12255
8 June 2017

**SECTION 96(2) MODIFICATION APPLICATION SSD 7388 – MOD 3
31 WHEAT ROAD, SYDNEY**

On behalf of Grocon (Darling Harbour) Developments Pty Ltd we hereby submit an application pursuant to section 96(2) of the *Environmental Planning and Assessment Act, 1979* (EP&A Act) to modify SSD 7388 relating to The Ribbon development (former IMAX site).

PROPOSED AMENDMENT

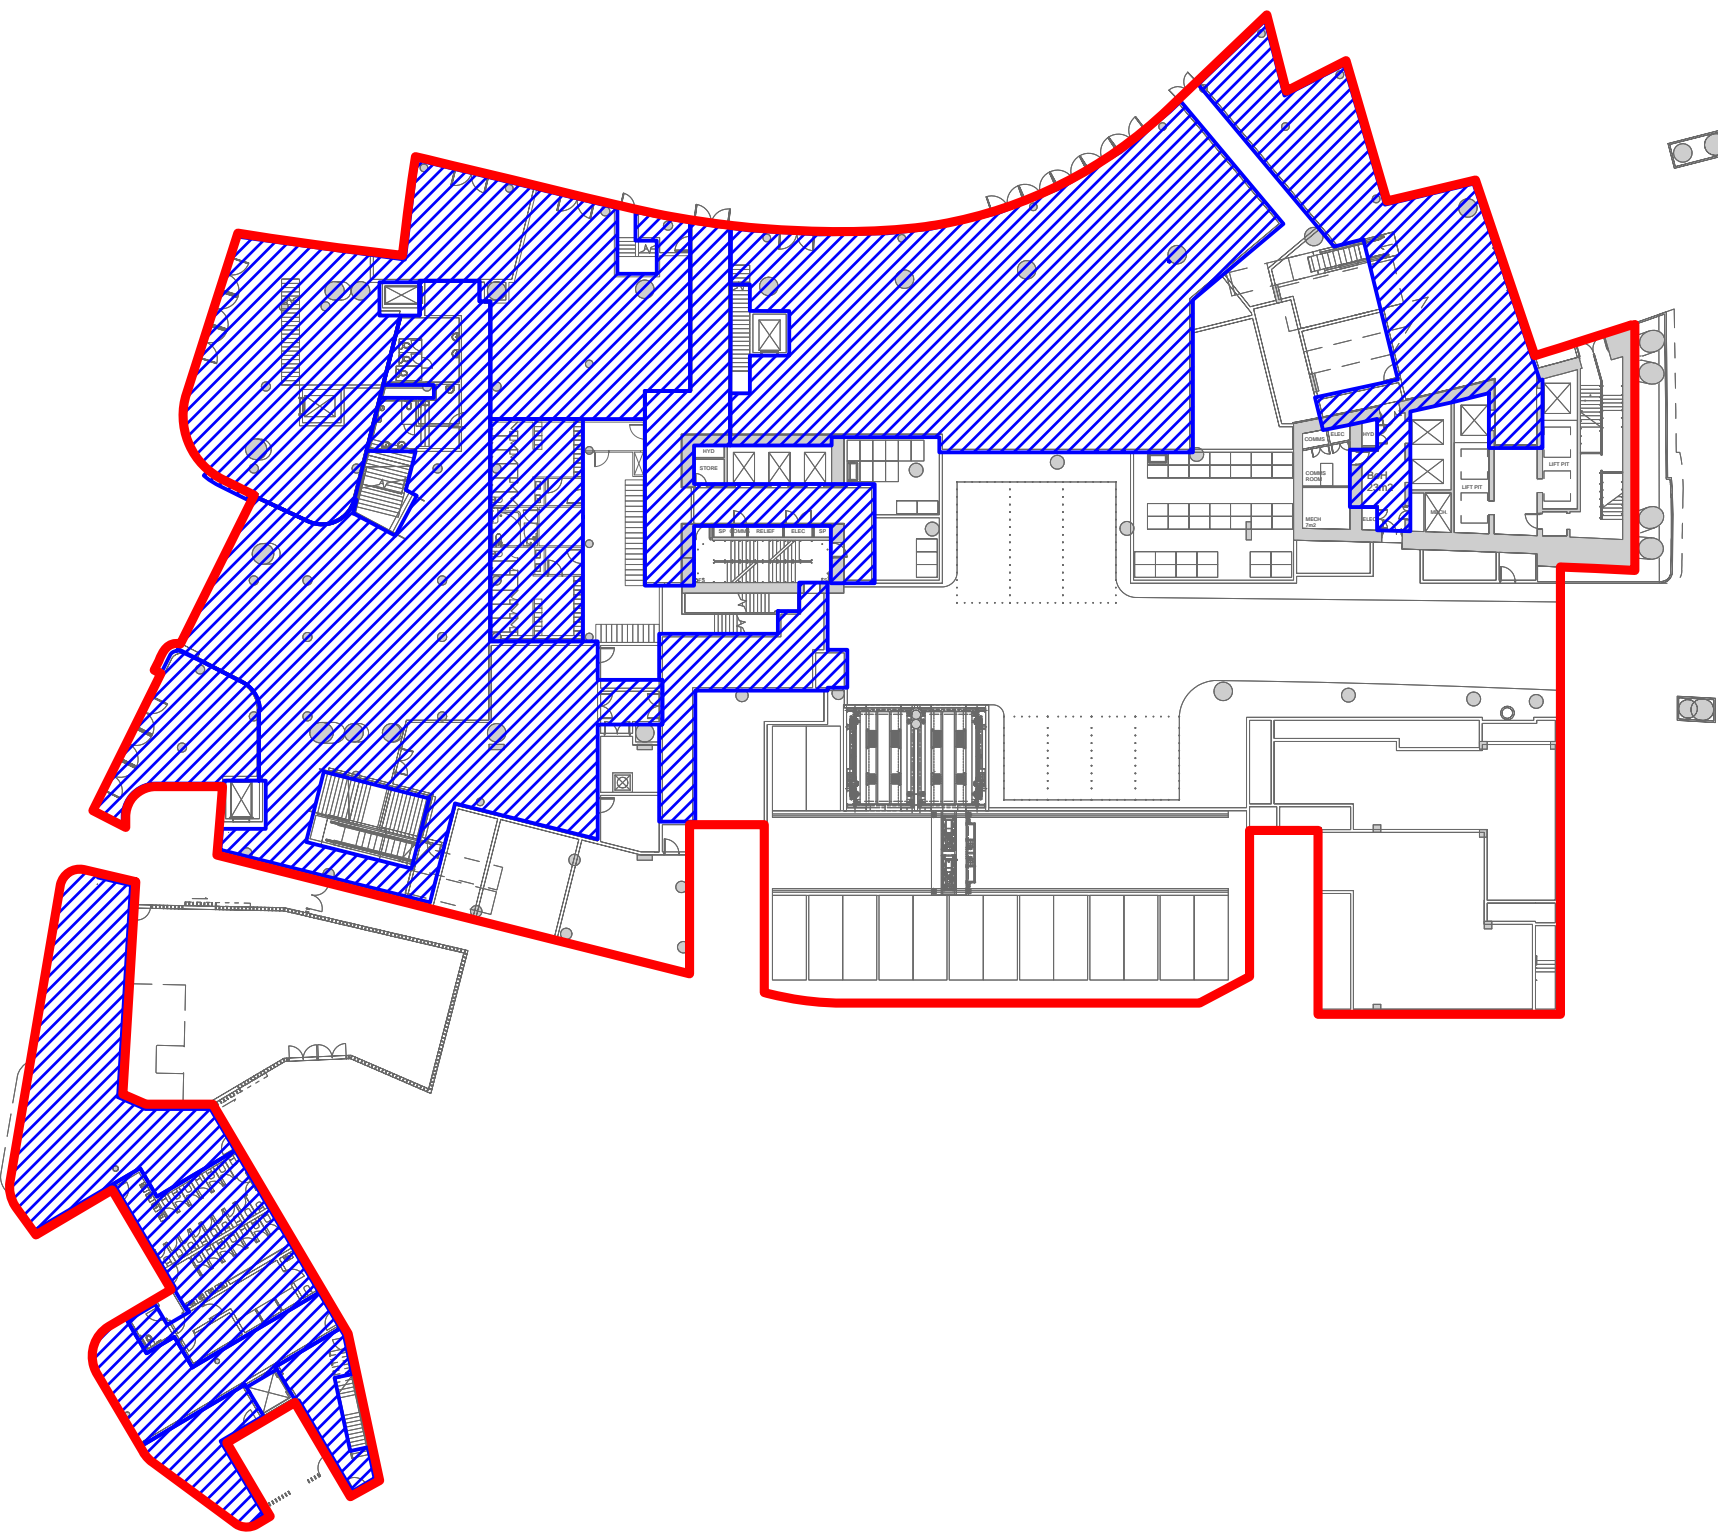
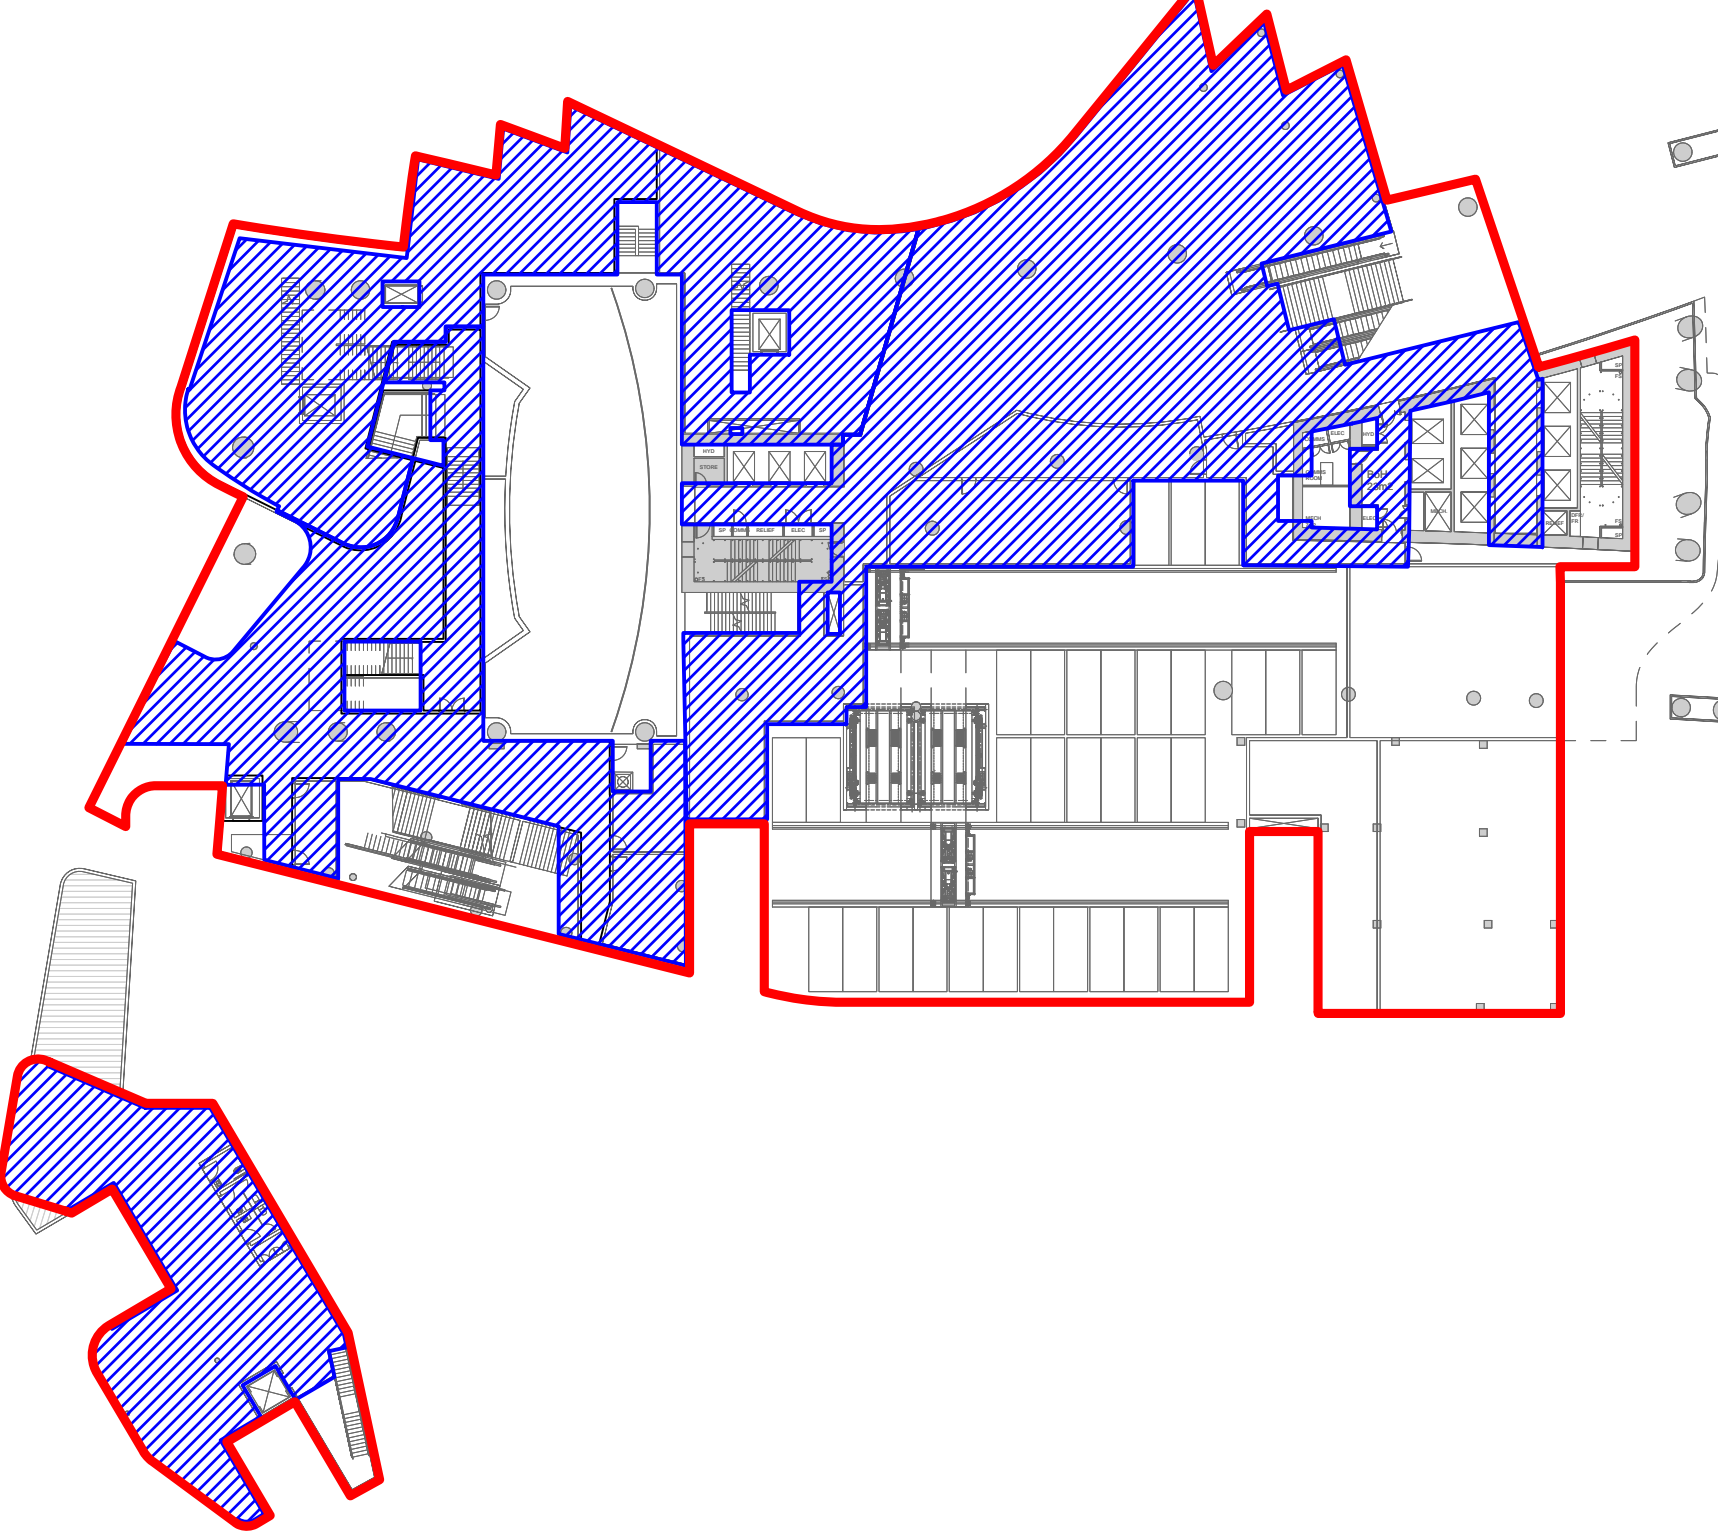
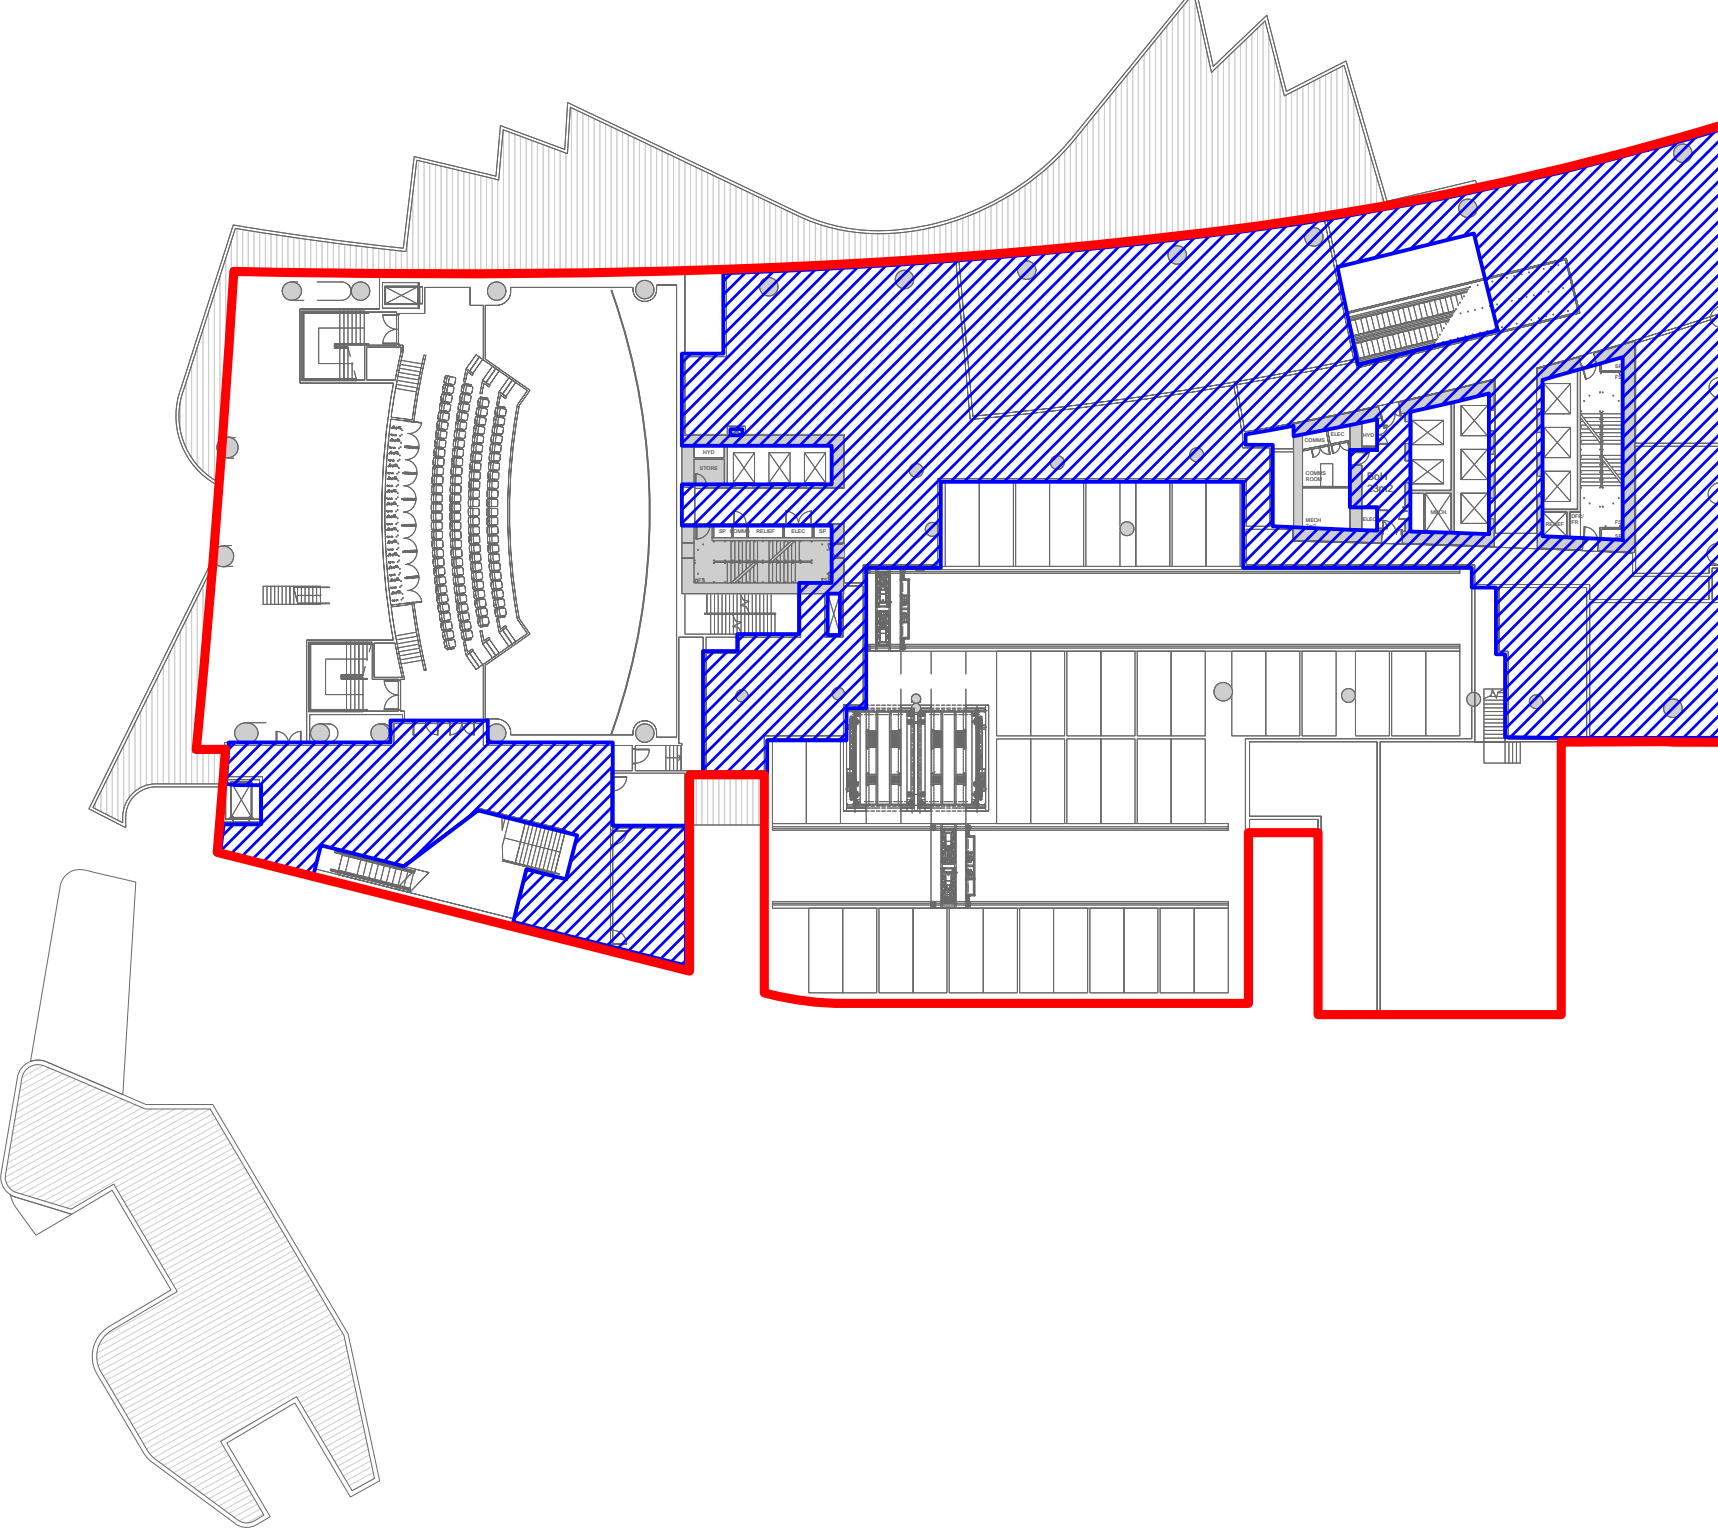
The revision of the building envelope necessitates the reconfiguration of the retail tenancies within the podium. The revised layout is shown in **Figure 2**. The proposed amendments increase the gross floor area(GFA) of the development by 107m² refer to the GFA calculations on drawing ARC-HSL-DD-SK-532.1.
